Recommendation Report for Approval of Reserved Matters Following Outline Approval

REF NO: LU/201/16/RES

LOCATION: Windroos Nursery
Worthing Road
Littlehampton

PROPOSAL: Approval of reserved matters following outline consent LU/229/10/ for appearance, landscaping, layout & scale for 84 No. dwellings

TITLE PROPOSED SITE PLAN - SHEET 2 OF 2

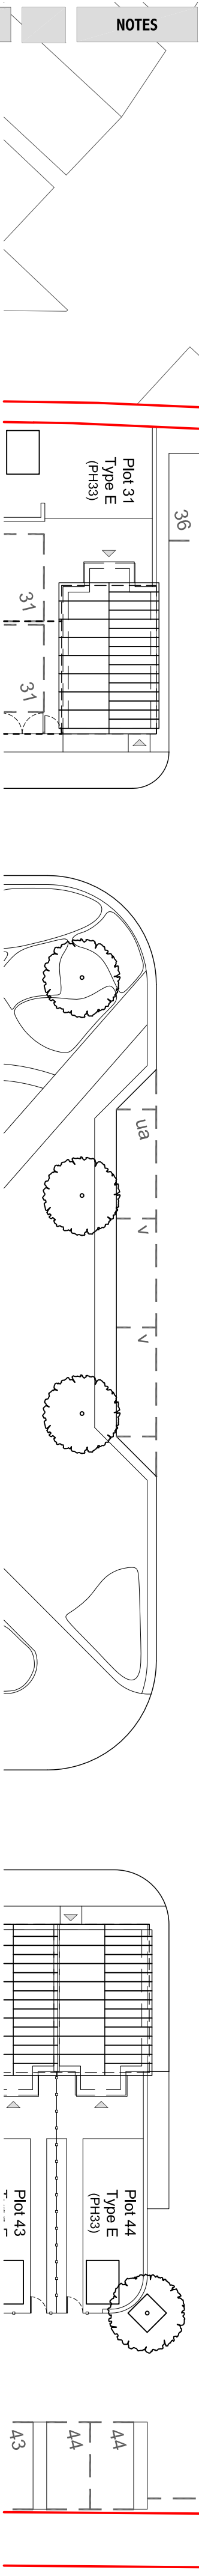
The addition of plot 32 to the revised plans is the only house that is placed right up against the perimeter fence / development boundary. Unlike other plots on the proposed development where the buildings are offset from their plot boundary by a garden, this property has no such offset on its westerly side. As such the view looking easterly from the neighbouring development is only one of an imposing brick elevation in relation to this plot and one that is more imposing than other plots on the proposed development.

- It is recommended that the parking spaces north of plot 62 are located behind the footway instead of the layout as shown. This would make defining the extent of adoption more straightforward, i.e. it would be the back edge of the footway. Given that the exact extents of adoption are not clear, it may well be that this access road is not being offered for adoption. The parking spaces have been moved to the back of the footway. This length of access road is in any case now shown as being private.

- The kerb radii at the junction at the frontage of plot 63 should be enlarged as much as possible. The logic of the layout shown is acknowledged (that there is no through route from the proposed development into the adjoining completed development and as such there would be no reason for traffic to turn right). However the Design Brief for Site 7 (which incorporated both the adjacent completed and currently proposed development) envisaged a through route.

· In connection with the above, there are quite a number of side roads where it appears that these will be accessed by formalised bell mouths with kerb radii. Given the low number of parking spaces served from these, these could alternately and more preferably have been accessed by crossovers. This would then give priority to pedestrian movements rather than vehicular traffic.

Plot 32 is located away from the boundary of the neighbouring garden on Faulkner Gardens as there is a separation gap which between the two residential sites. The proposed plot does not affect the amenity or overshadow to an unacceptable extent.

Whilst there is a ransom strip between the two sites at present, this may be overcome. The design should be altered to reflect this. The kerb radii have been removed altogether and the access road indicated as being private. Putting aside matters of land ownership/control, whilst this would not preclude a through access in principle for pedestrians, given the alignment proposed does not reflect that within the adjoining development, it would be difficult to connect the two sites together for vehicle traffic.

The layout has been altered in certain instances to give greater priority to pedestrian movements.
